CITY OF ALBUQUERQUE

November 29, 2017

**Re: RV Parking
7800 Jacs Lane
Traffic Circulation Layout
Architect's Stamp 11-07-17 (D16-D002A6)**

TRAFFIC CIRCULATION LAYOUT  
APPROVED  
Signed: [Signature] Date: 01-09-18

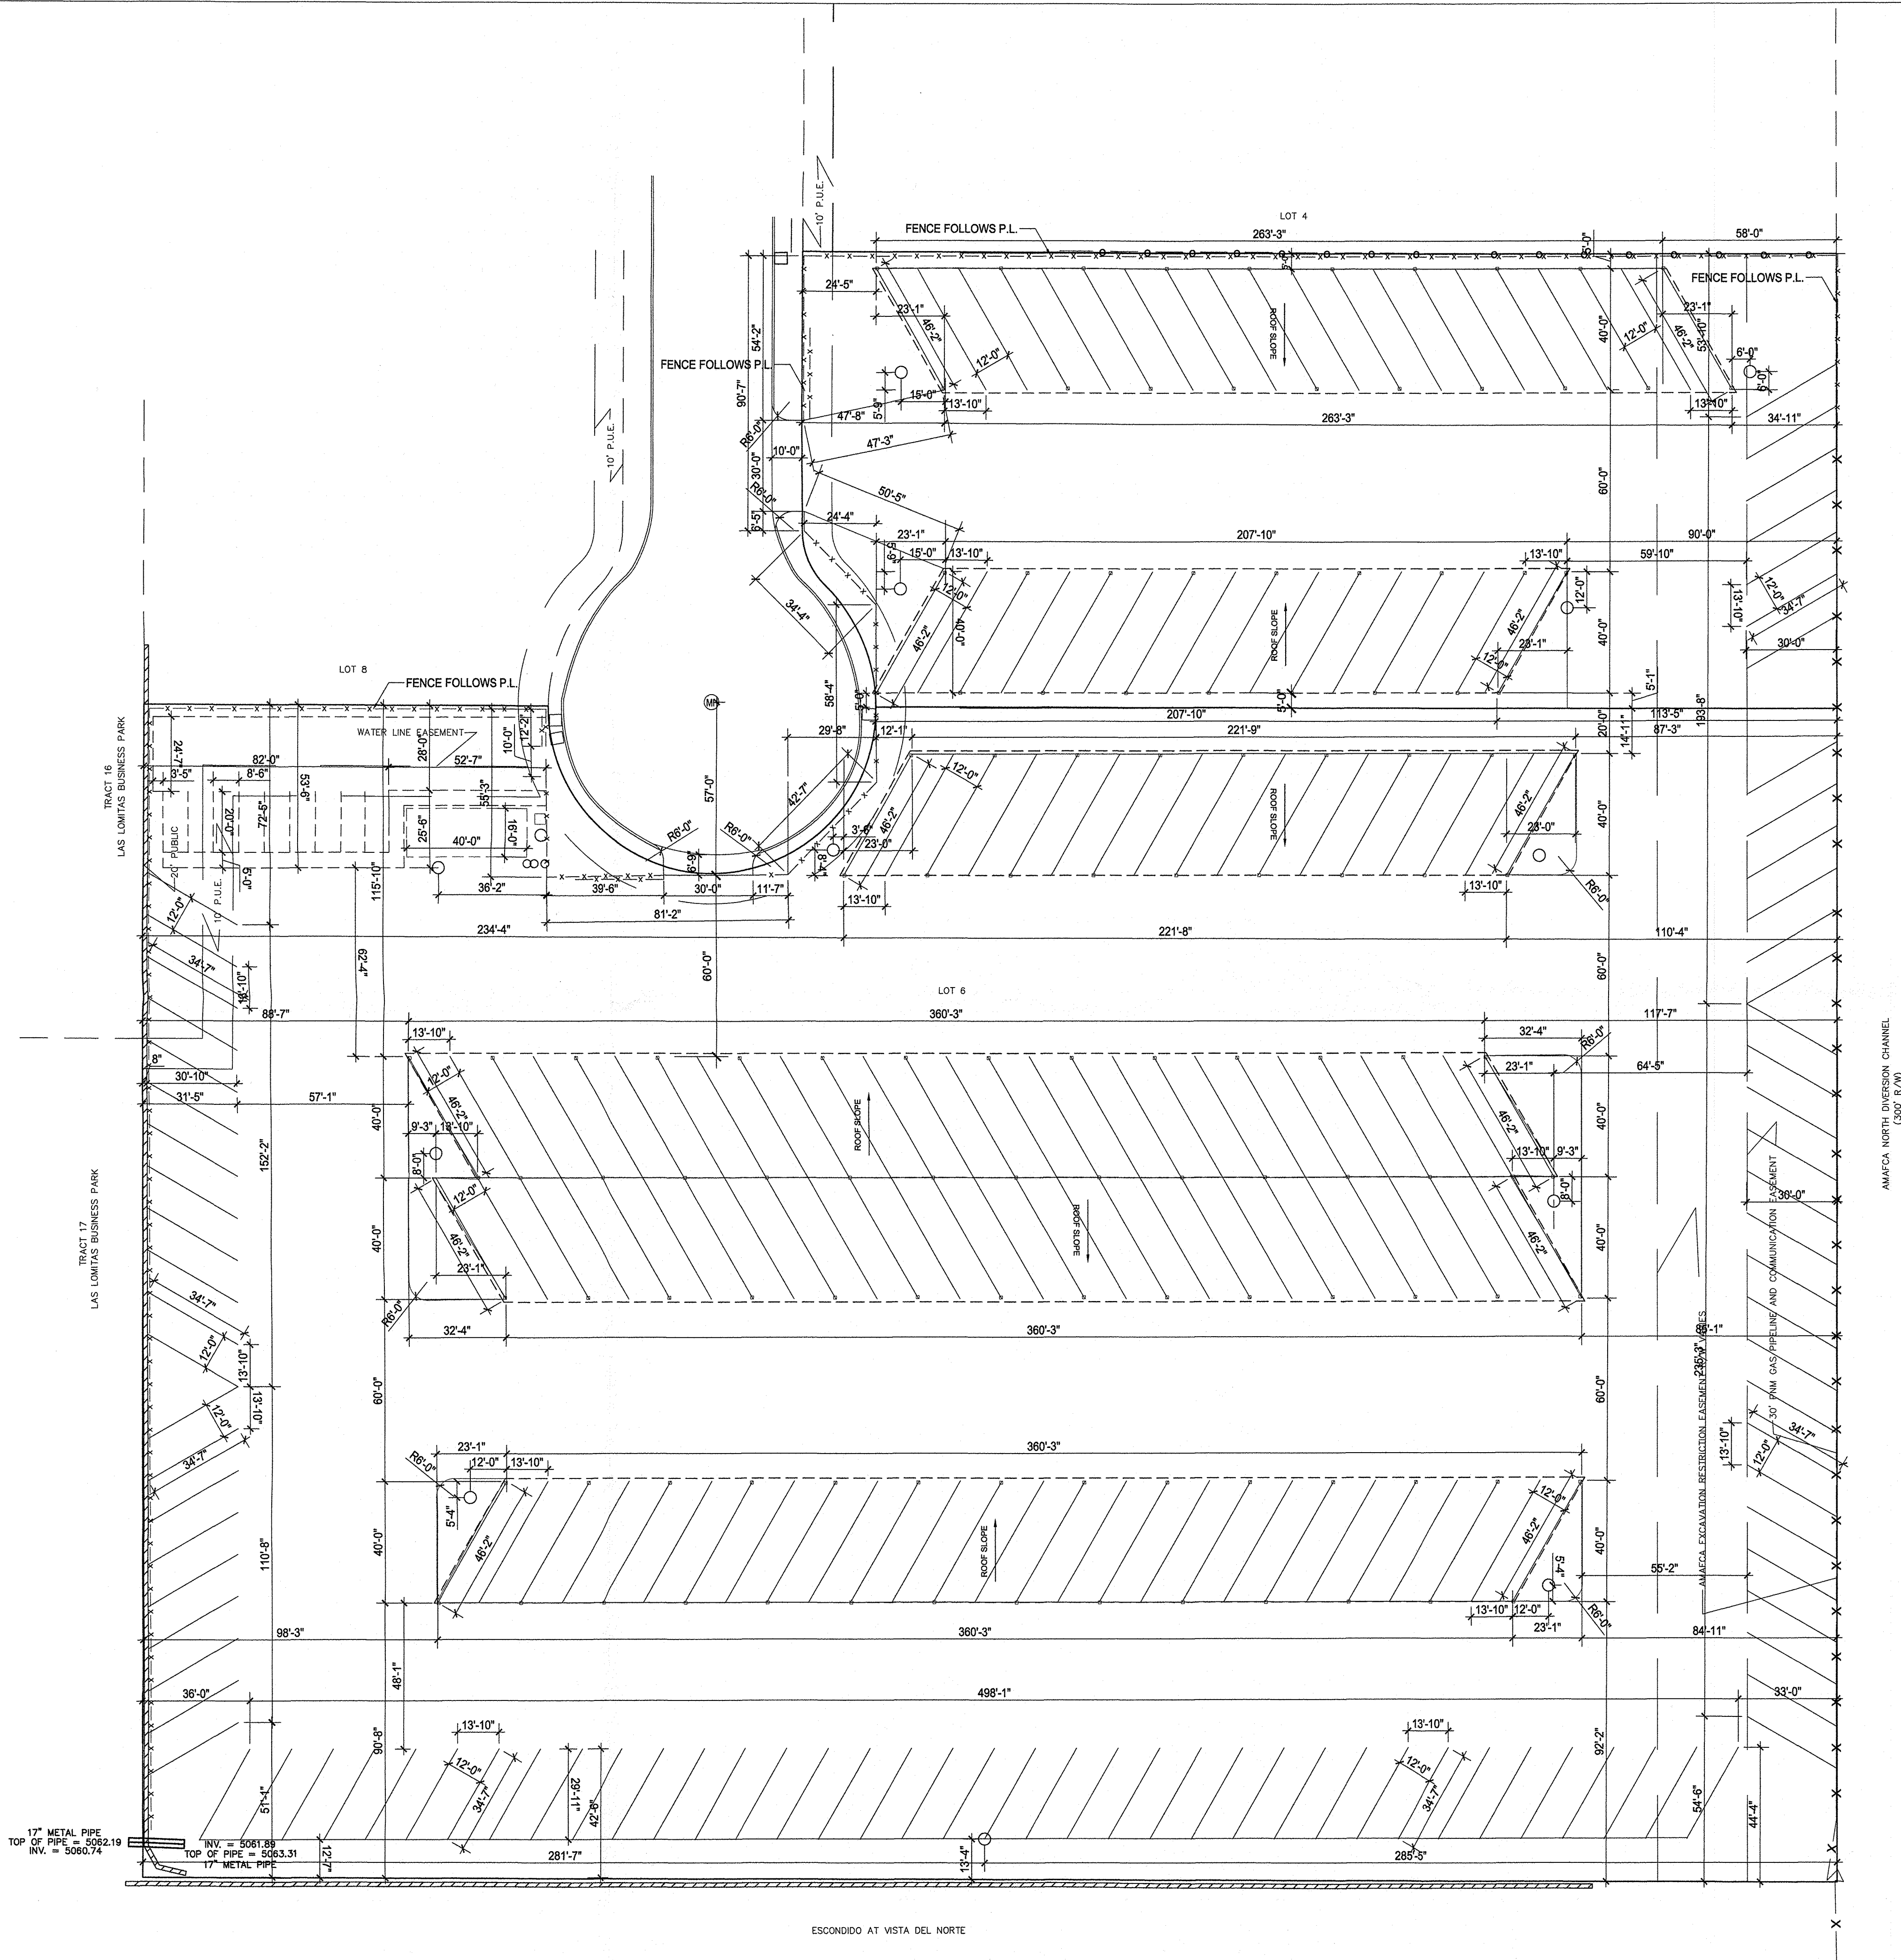
1. Please review and revise plan to provide all information listed on the attached Traffic Circulation Layout checklist.
2. Please refer to the attached Accessible Parking Checklist and revise the plan accordingly.
3. The site will need to be re-platted, parking space cannot cross lot lines.
4. Please include two copies of the traffic circulation layout at the next submittal.
